Jeanie Bourke - RE: 563 Forest Ave., BP#2014-00065, plan review comments

From: "David Graham" <david.graham@grahamarchitects.com>
To: "Jeanie Bourke" <JMB@portlandmaine.gov>, "Paul Ureneck" <PUreneck@Bo...>
Date: 2/26/2014 12:49 PM
Subject: RE: 563 Forest Ave., BP#2014-00065, plan review comments
Attachments: A3 PROPOSED PLAN.pdf; 300-W-60R-IIXL.pdf; SuperLite II-XL 60.pdf

**\* 300-W-60R-IIXL \***

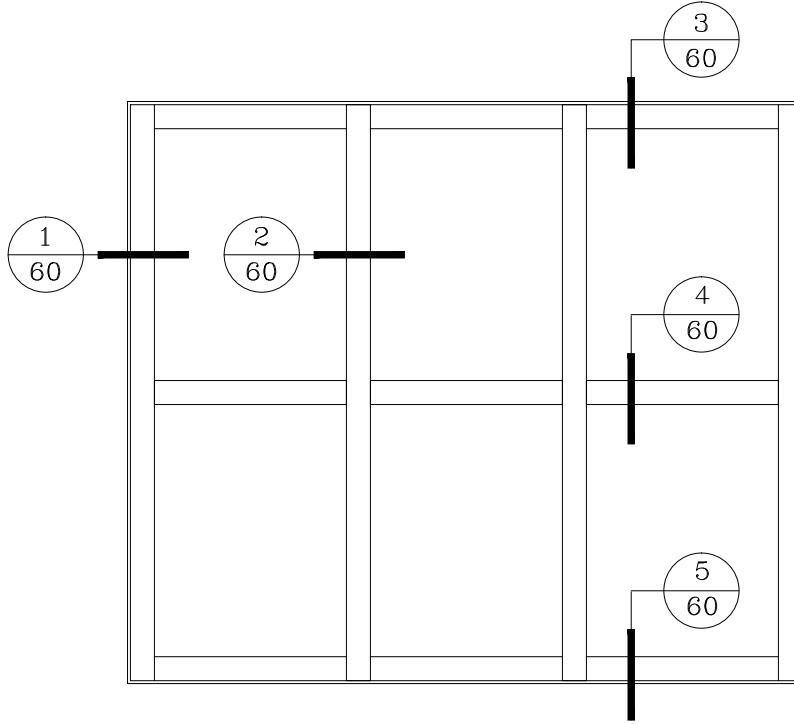
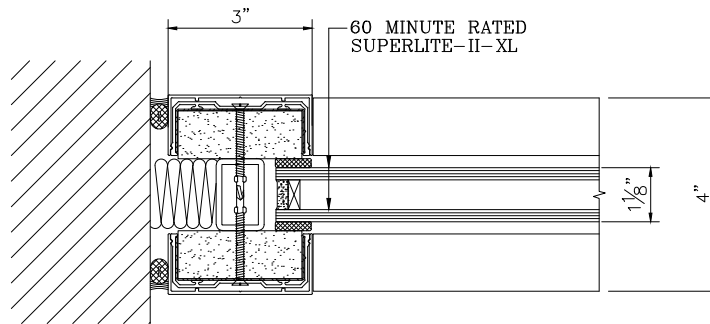
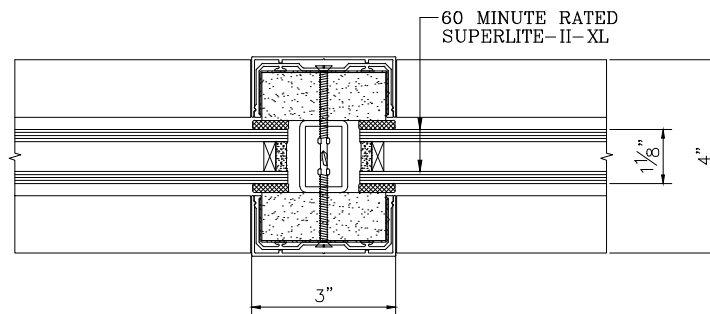
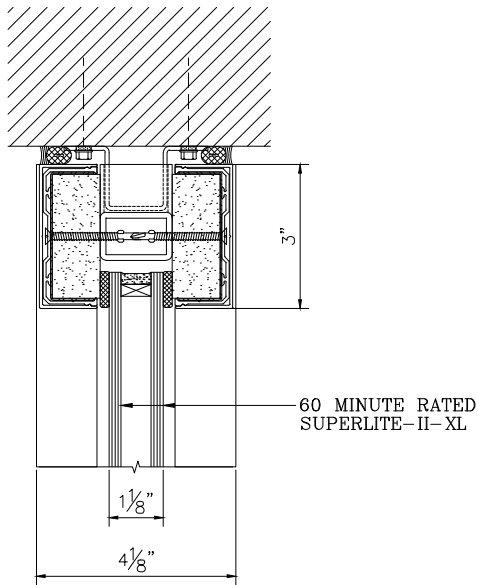
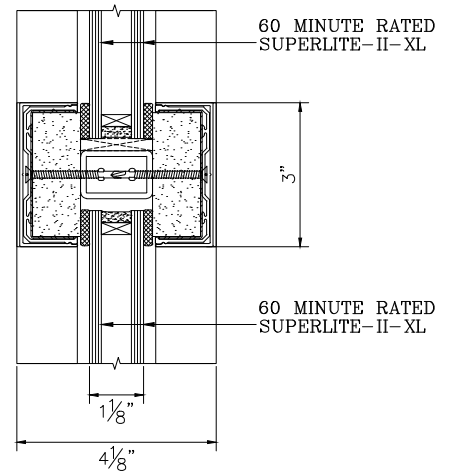
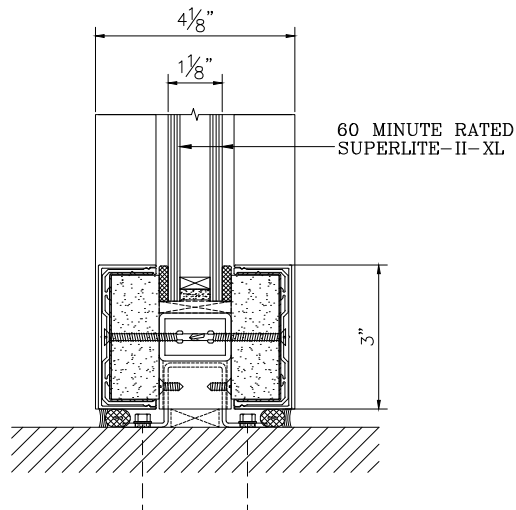
I spoke with my fire risk management consultant and they indicated that a window is permitted by code provided it meets the testing standards for the rated wall assembly, ASTM E119 and NFPA 251. This condition is referred to as a "Transparent Wall". I have specified a product Superlite II-XL or equal on the attached drawing. I am currently looking at pricing options with the general contractor. I will submit the final product data sheet once it has selected.

I've also attached the cut sheets and a standard detail from Superlite for your review.

EGRESS PLAN AND LIFE SAFETY EQUIPMENT

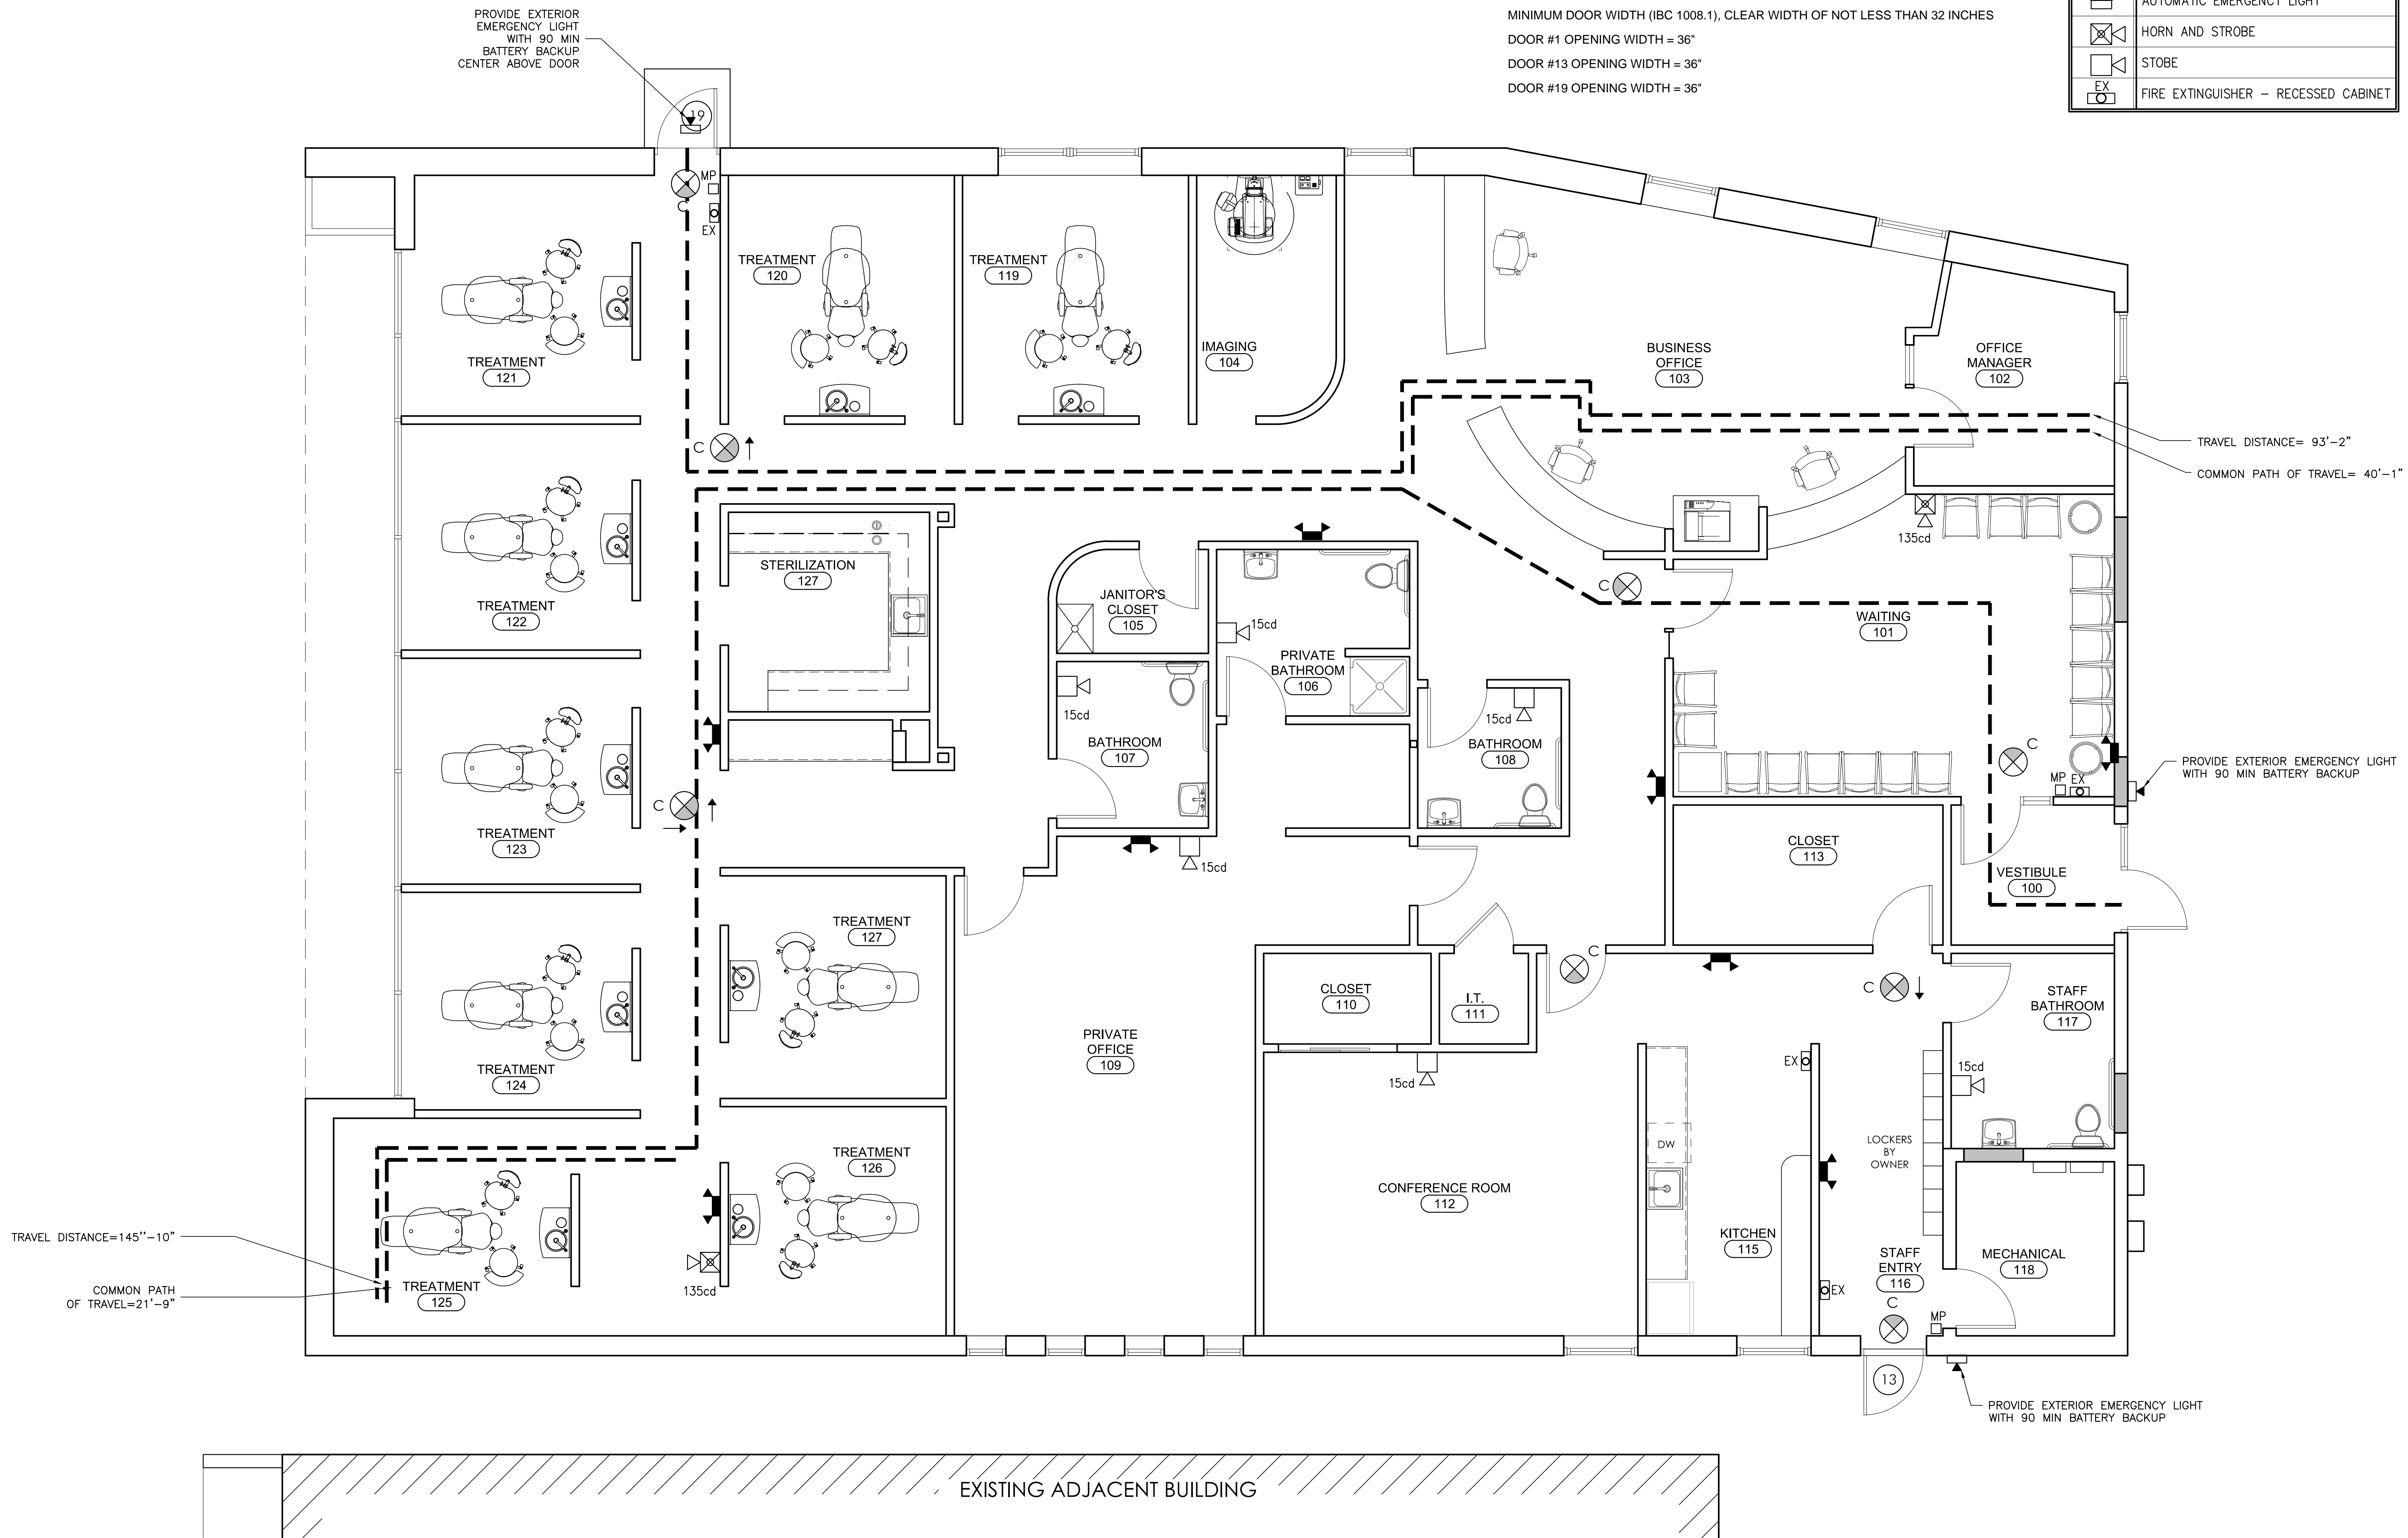
Jeanie Attached is the revised plan. I have relocated the egress door to the Coyle St side of the building.
